WELWYN HATFIELD COUNCIL – DEVELOPMENT CONTROL
DELEGATED REPORT

APPLICATION No:	S6/2008/2224/MA
------------------------	------------------------

This application seeks full planning permission for change of use of land to C3 dwelling houses, extensions and conversion of barn to create six bed dwelling plus staff accommodation. Erection of four two storey dwellings comprising of; 1 x three bed, 1 x four bed, 2 x five bed dwellings and ancillary car parking and landscaping following demolition of existing buildings.

Drawing N° 07
 KEY PLAN &
 ROOF PLAN

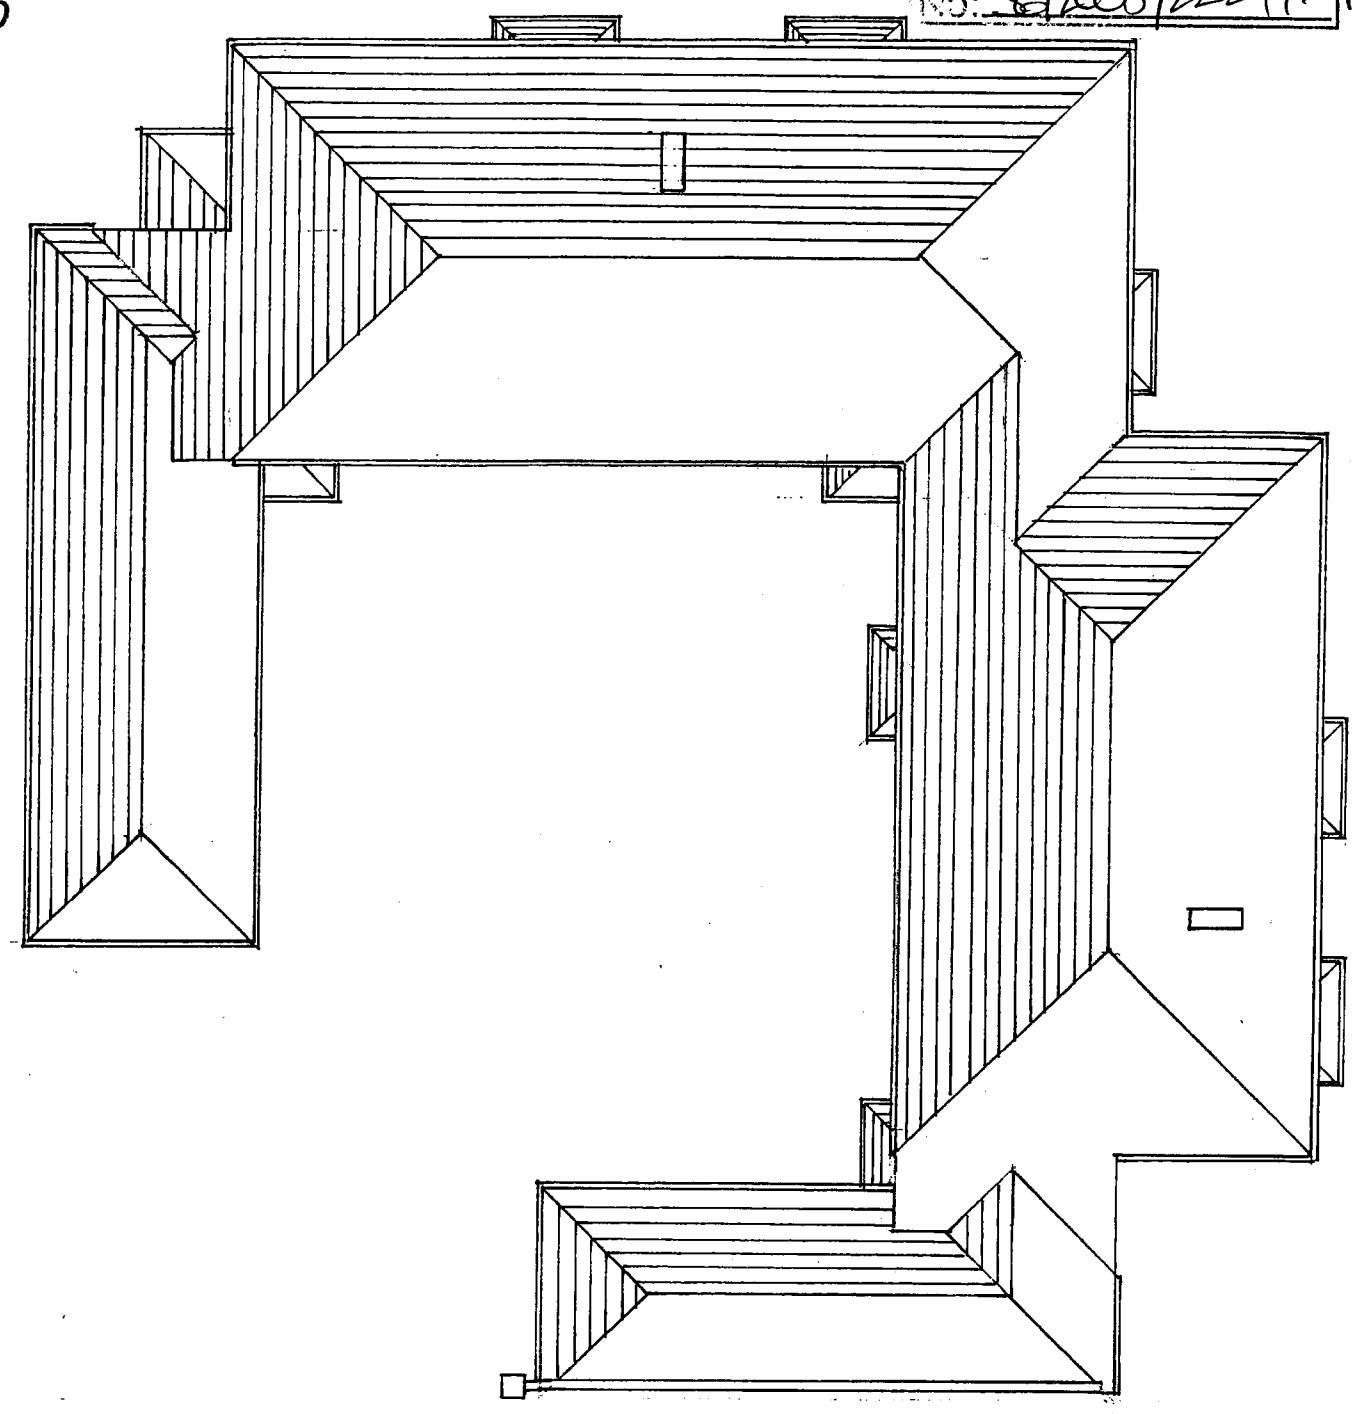
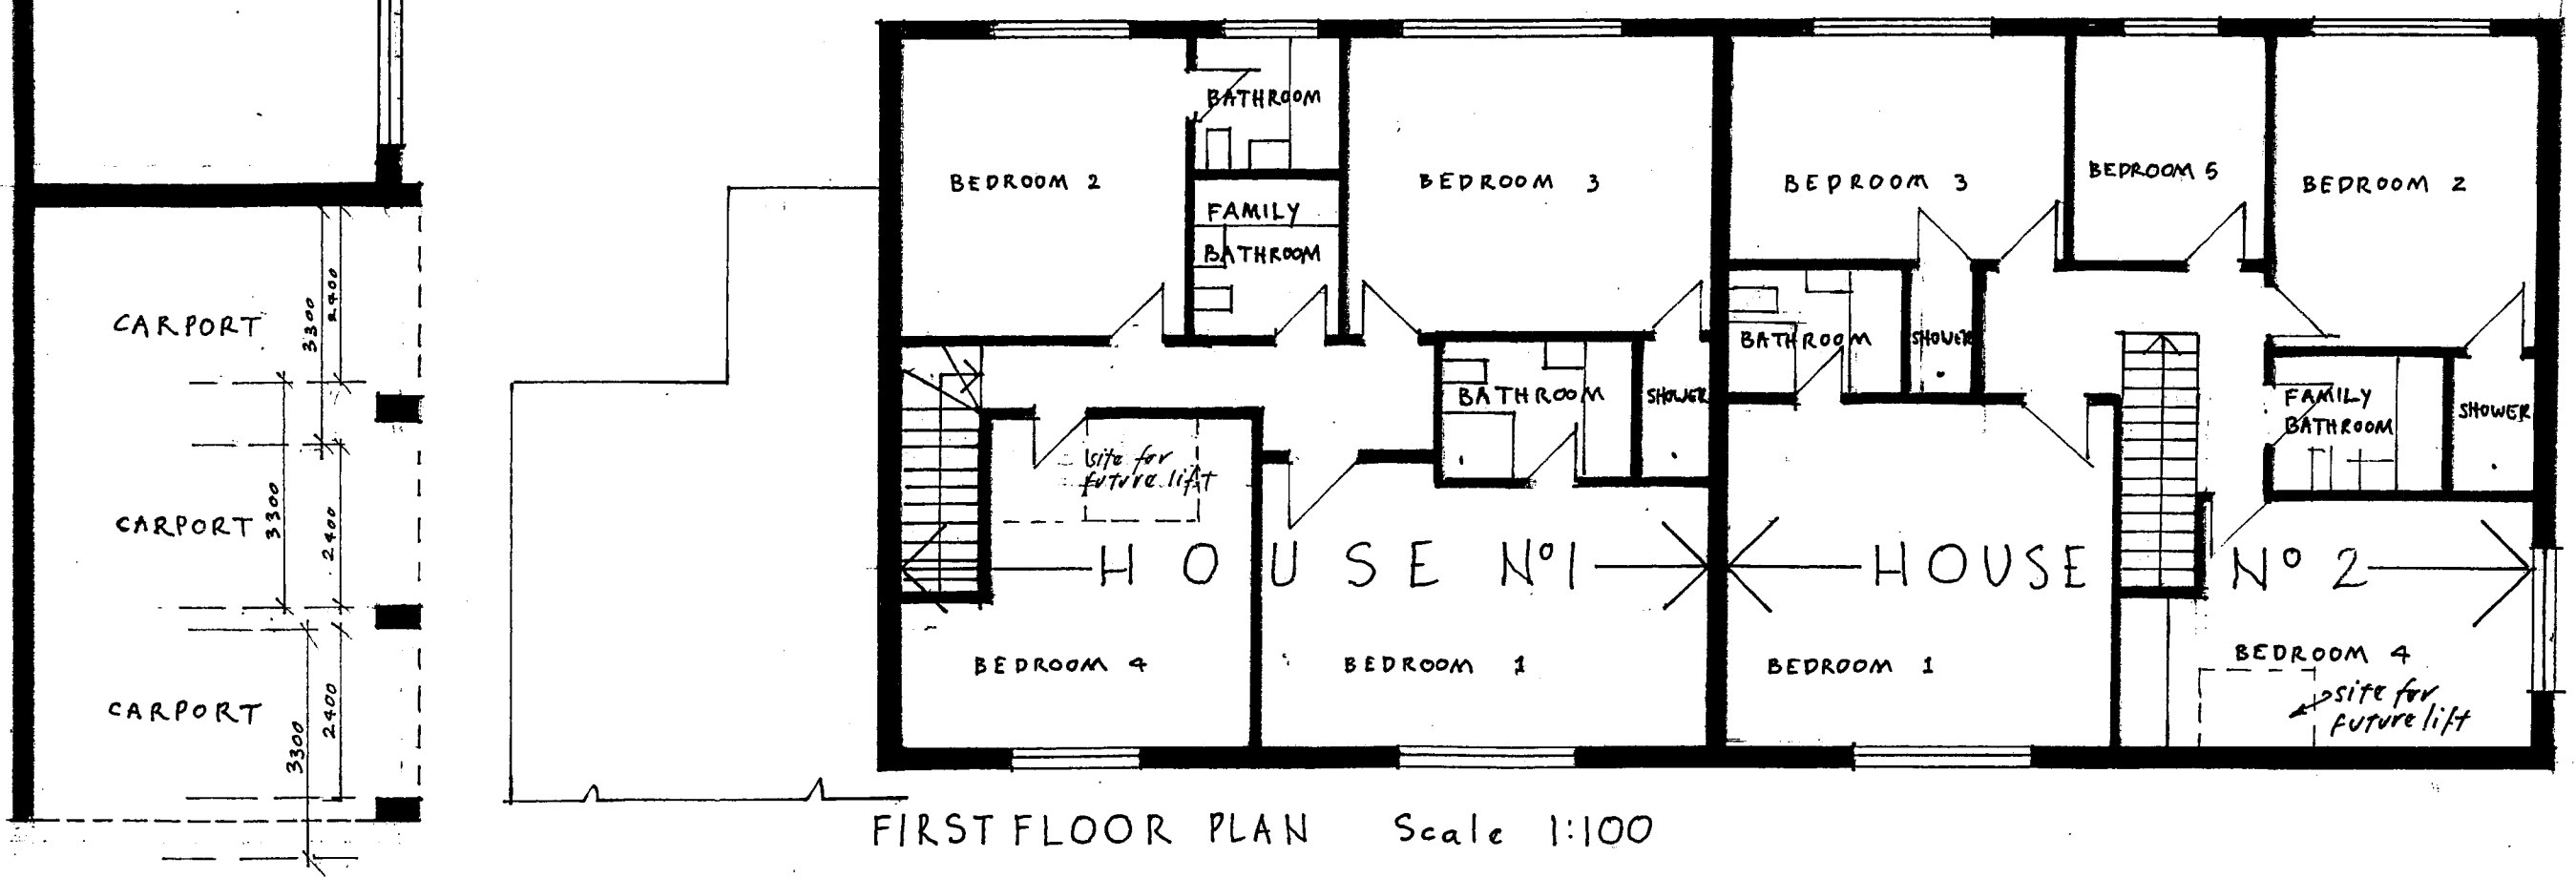
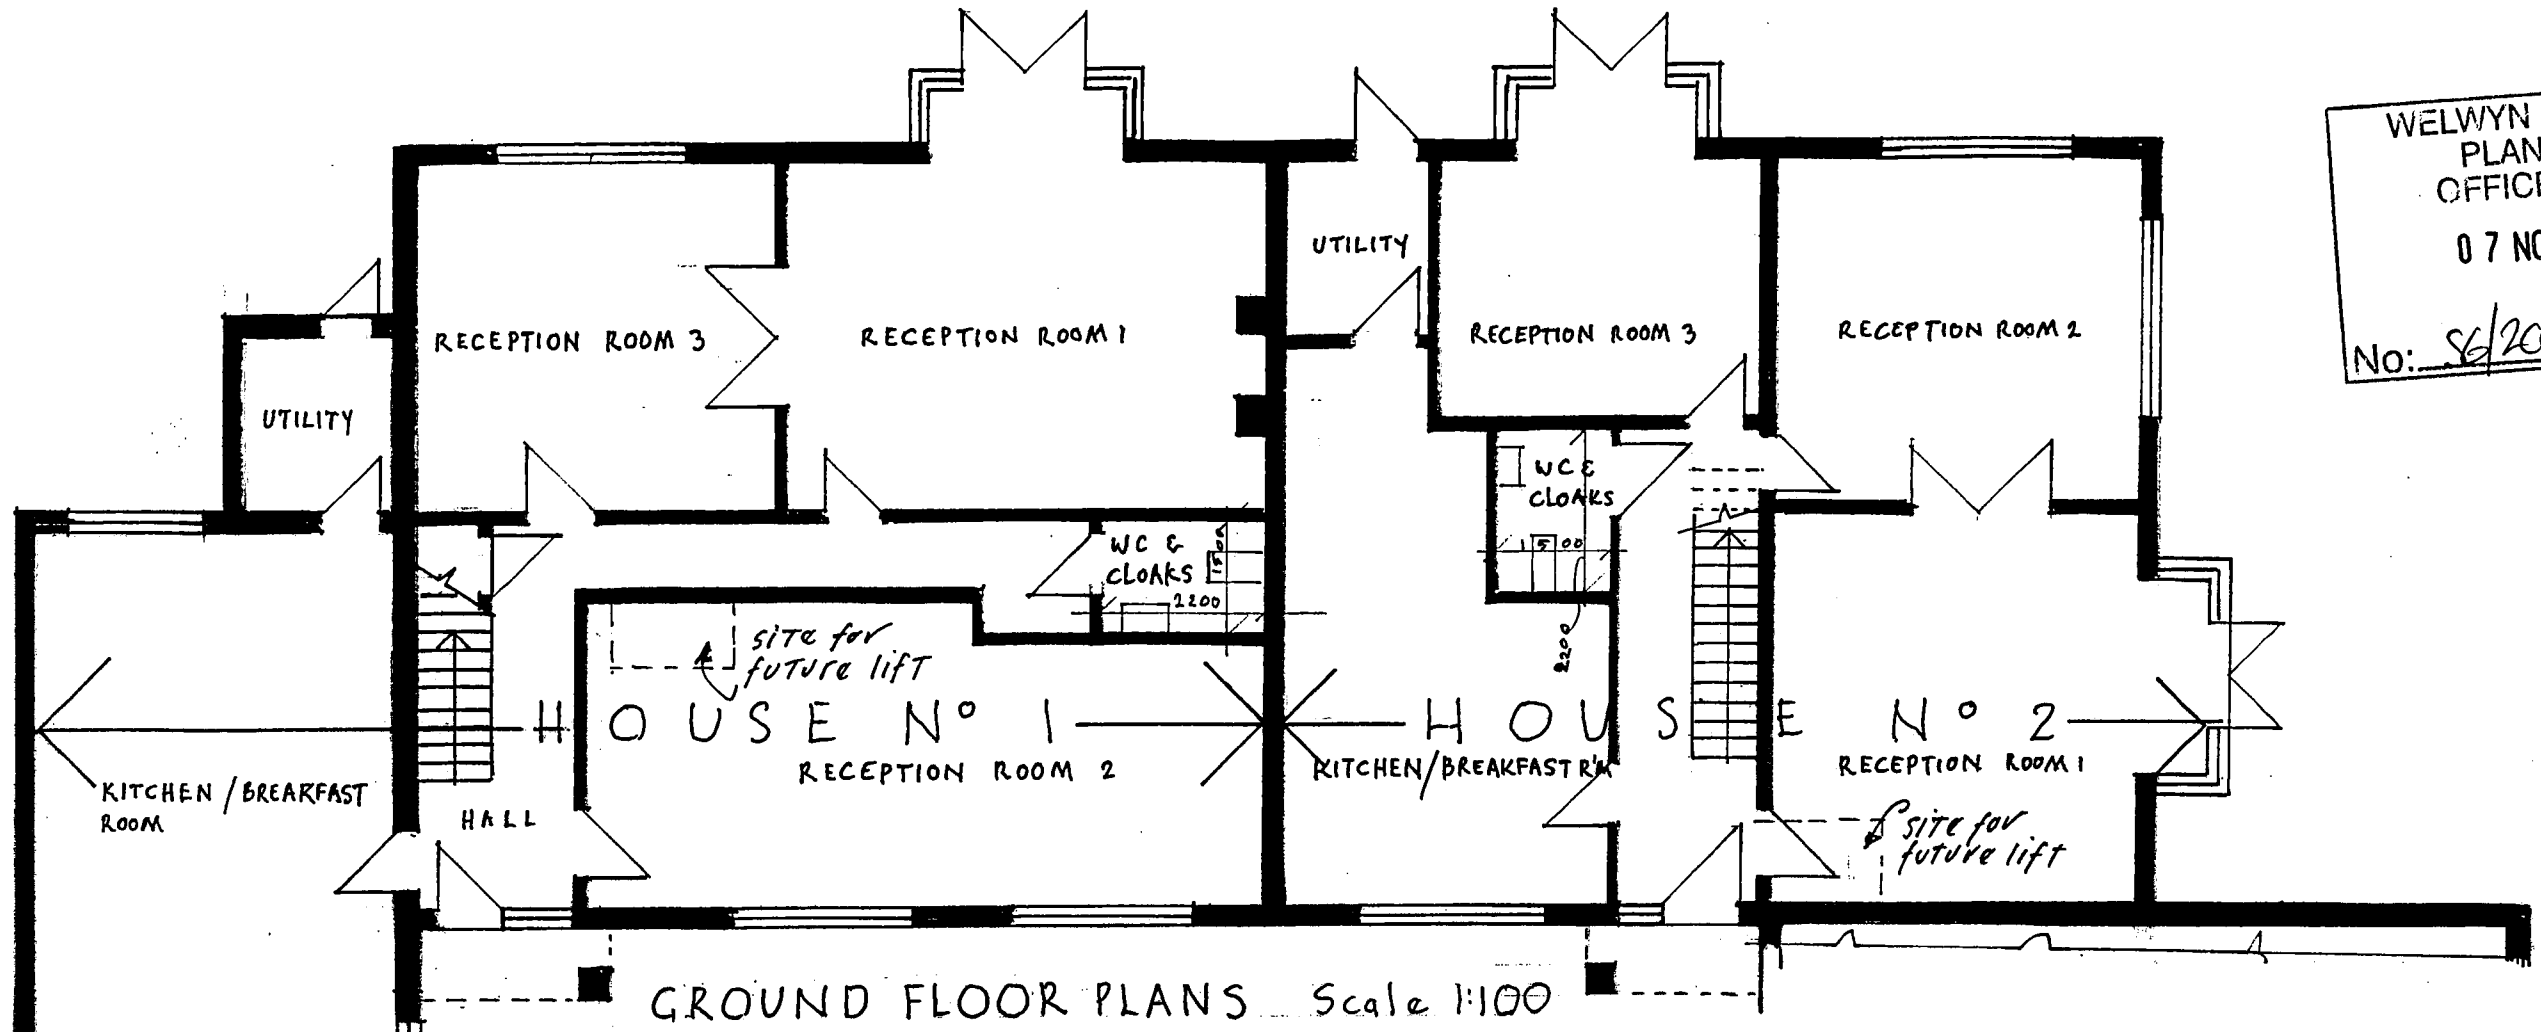
The existing buildings are not unduly harmful to the rural setting of the application site, given that the existing barns and stables are not out of keeping with the style of agricultural buildings that are common within a Green Belt location. From this basis it is considered that the proposal to erect four two-storey dwellings in replacement would result in the perception of greater suburbanisation of the rural area to the detriment of the rural setting. Furthermore, it is considered that the design intricacies of a dwelling are such that they have a greater impact on the character and appearance of the street-scene than the simplicity of the existing built form. Although the proposed new dwellings are considered to be of appropriate design in that they would not be unduly out of keeping with the surrounding properties, it is considered that the detailing results in the prominence of the dwelling being increased, thereby negating any benefit from the partial reduction in the volume of the built form at the site.

As discussed within section 2 above, the proposed new dwellings are considered to be of appropriate design in that they would not be unduly out of keeping with the surrounding properties in terms of architectural style, windows, detailing and materials. However, the perception of greater suburbanisation would have an adverse visual impact upon the character and appearance of a rural area.

1. The site lies within the Metropolitan Green Belt where there is a presumption against inappropriate development. The four new dwellings proposed would be visually intrusive in the landscape to the detriment of the openness, character, appearance and visual amenity of the Green Belt. As such, the proposal represents inappropriate development and no very special
